DECISION DELEGATED TO DEVELOPMENT MANAGER

Application No: H03-0156-19 **Applicant:** Mr D Brennan

Proposal: Erect a shed and fence with garden gate, develop front area to allow for parking

Location: Chapel Las Nomad Main Road Deeping St Nicholas

A105

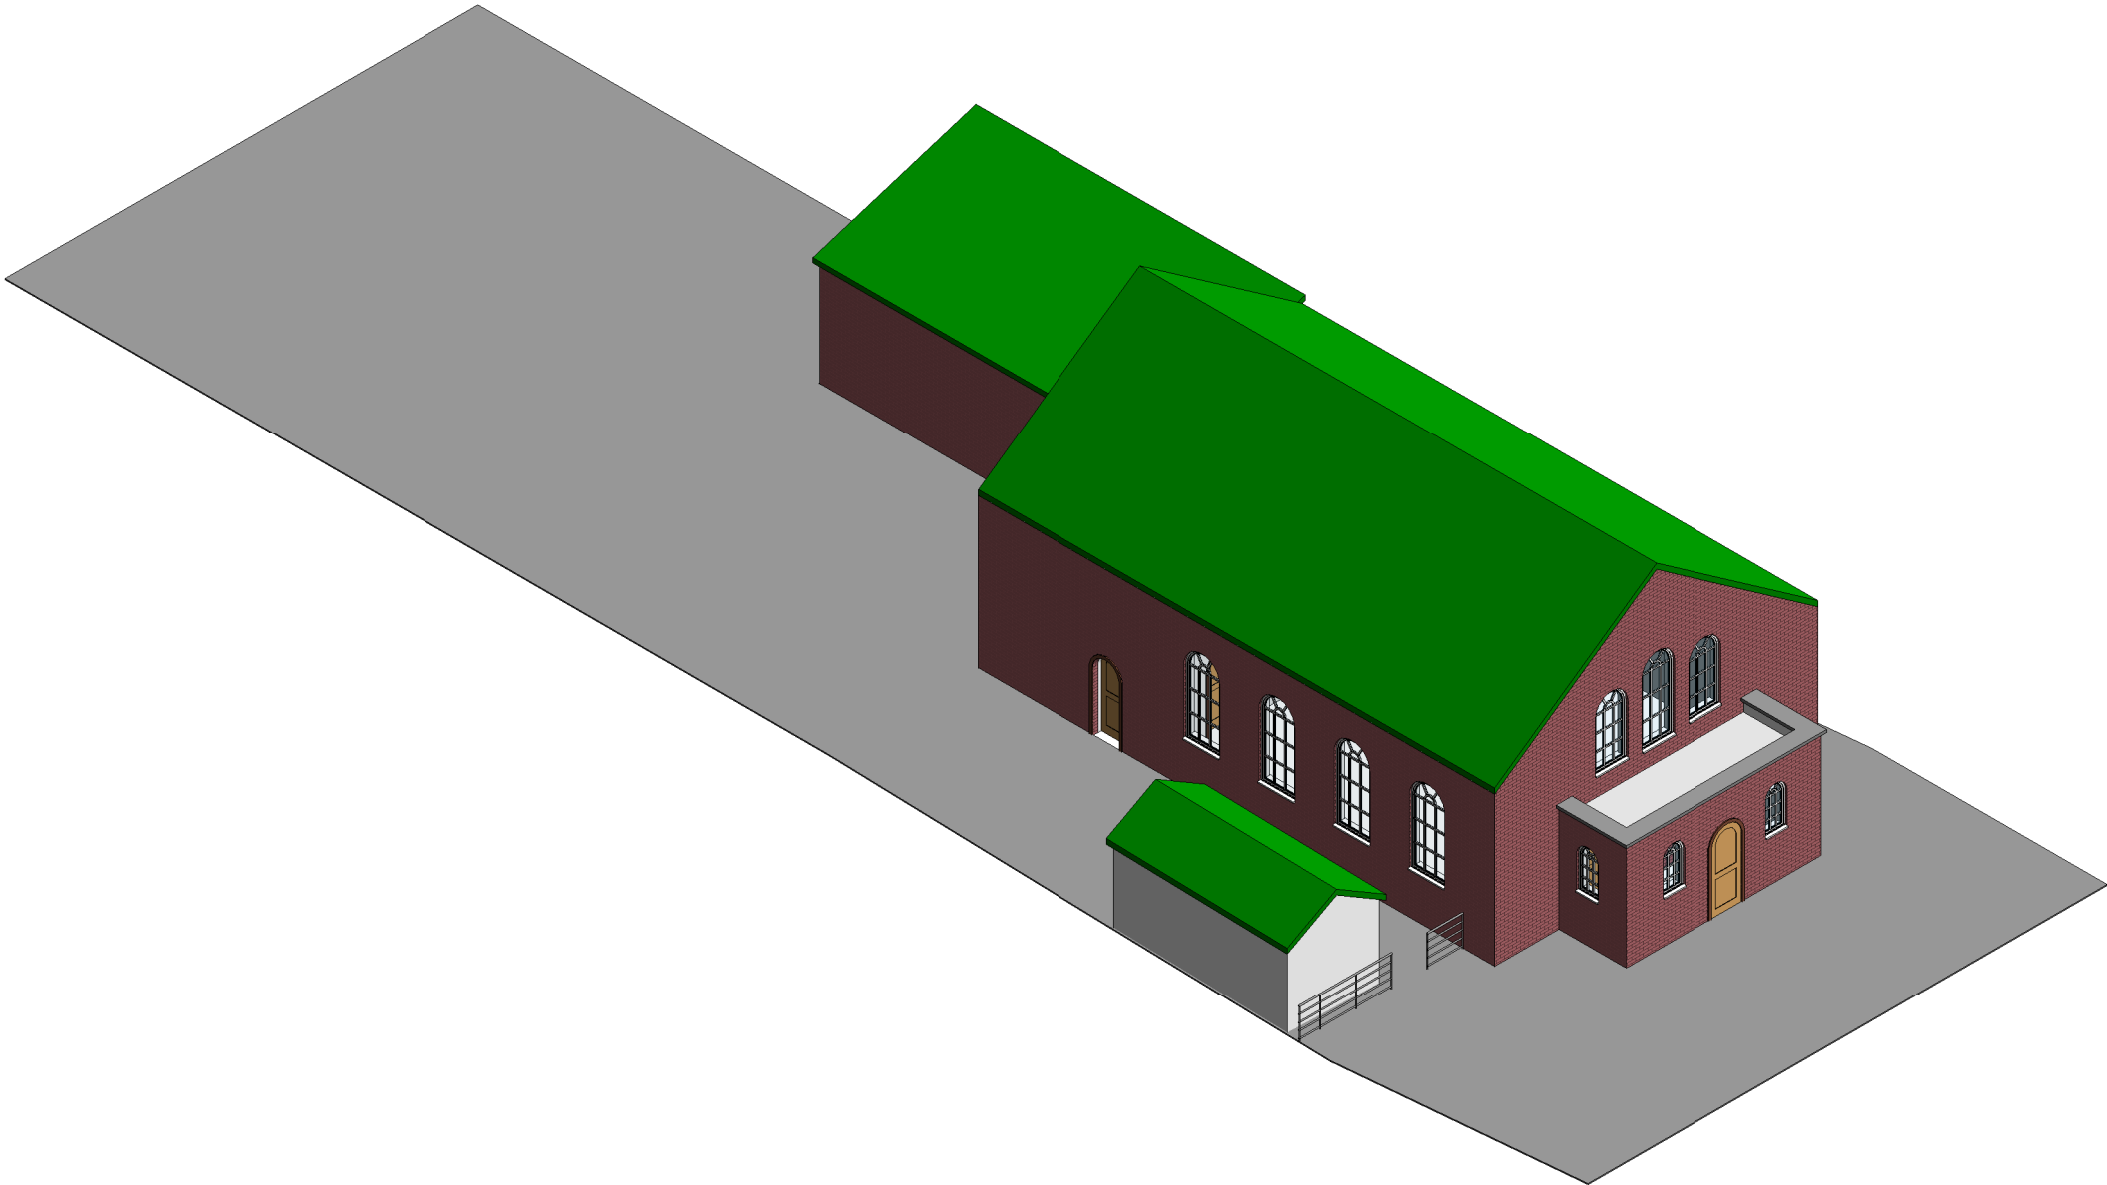
The former proposal indicated that the shed would be almost aligned with the front elevation of the old Methodist chapel and next to its western side elevation. In view of the concerns from the County Historic Environment Officer, it was required to amend the proposal to avoid any visual obstruction to the building given its architectural and historic merit. The final proposal still shows the outbuilding by the side of the western elevation but nearly the entire massing beyond the original rear wall of the building. In doing so, no visual intrusion would be caused on to the wider street scene and to the amenity of the old Methodist Chapel. Therefore, the proposed shed would not harm the historical and architectural significance of the asset.

As mentioned, the County Historic Environment Officer had made a negative review but the objection has been withdrawn after assessing the amended plans. No other representation has been made.
